DWIRE STORAGE YARD FILING NO. 1

A PARCEL OF LAND IN THE SOUTHWEST QUARTER (SW 1/4) OF SECTION 28,
TOWNSHIP 13 SOUTH, RANGE 65 WEST, OF THE SIXTH PRINCIPAL MERIDIAN,
EL PASO COUNTY, STATE OF COLORADO

FINAL PLAT
DWIRE STORAGE YARD FILING NO. 1
JOB NO. 43-117
DATE PREPARED: 01/23/2020
DATE REVISED: 01/08/2021

SHEET 1 OF 2

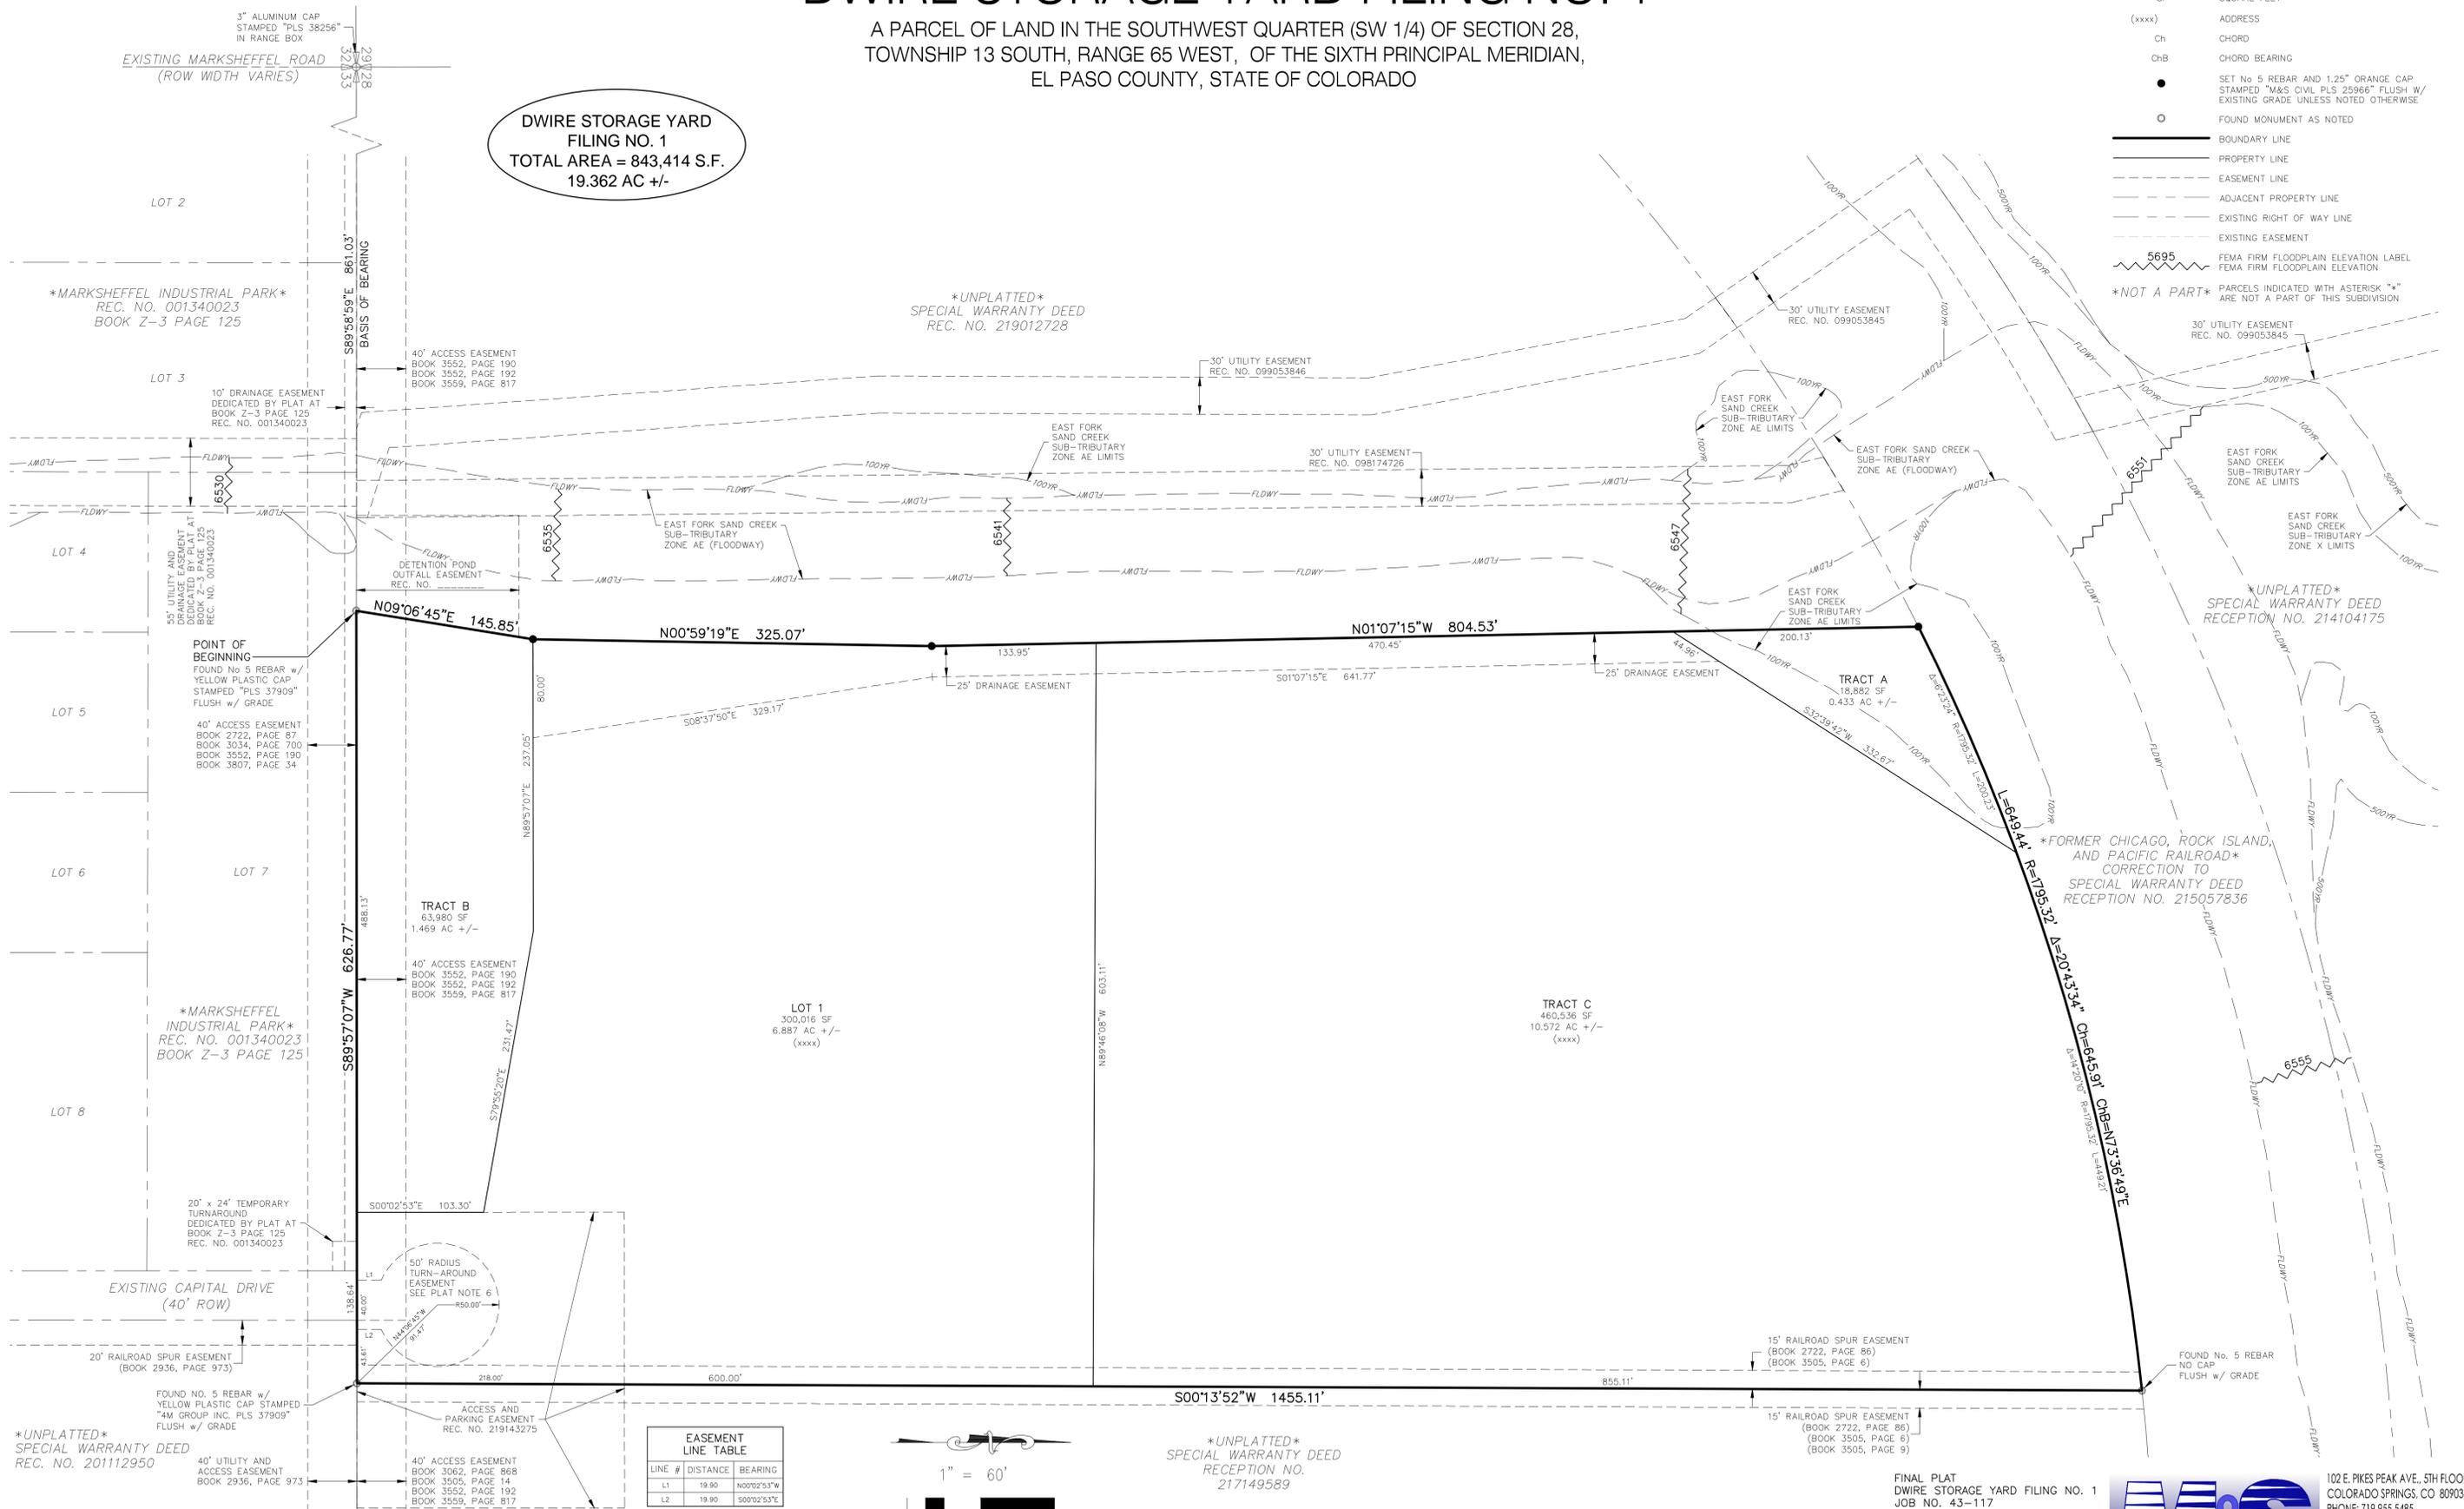
The majority of the standard plat notes are missing- there are too many to place on this plat as comments. please review and add a note regarding reports on file, easements, environmental, address, mailbox, SIA, driveway, drainage, water supply, floodplain, PID (if applicable), cherokee

be aware that no structures are permitted in a tract unless the plat specifically allows for it. please add corresponding plat notes for the purposes of the tracts.

Include statement that gravel-surfaced storage yard only is allowed in Tract C in the Tract C note.

please be aware that the assessor signature is only needed if you are entering into a PID

Standard notes added to the plat notes; they are now too long to include on the cover sheet, so a new sheet 2 has been added for the plat notes.

Standard easement statement added to cover sheet, revised to reflect the particulars of this plat (commercial/industrial versus residential).

Tract table revised. New plat note 23 added (new sheet 2) identifying the purposes of all tracts.

Statement added to new plat note 23 identifying allowed uses for tracts.

Assessor's signature kept for the present, as there are questions about improvements to Capitol Drive and if inclusion into a PID is required. See new plat note 17 (new sheet 2).
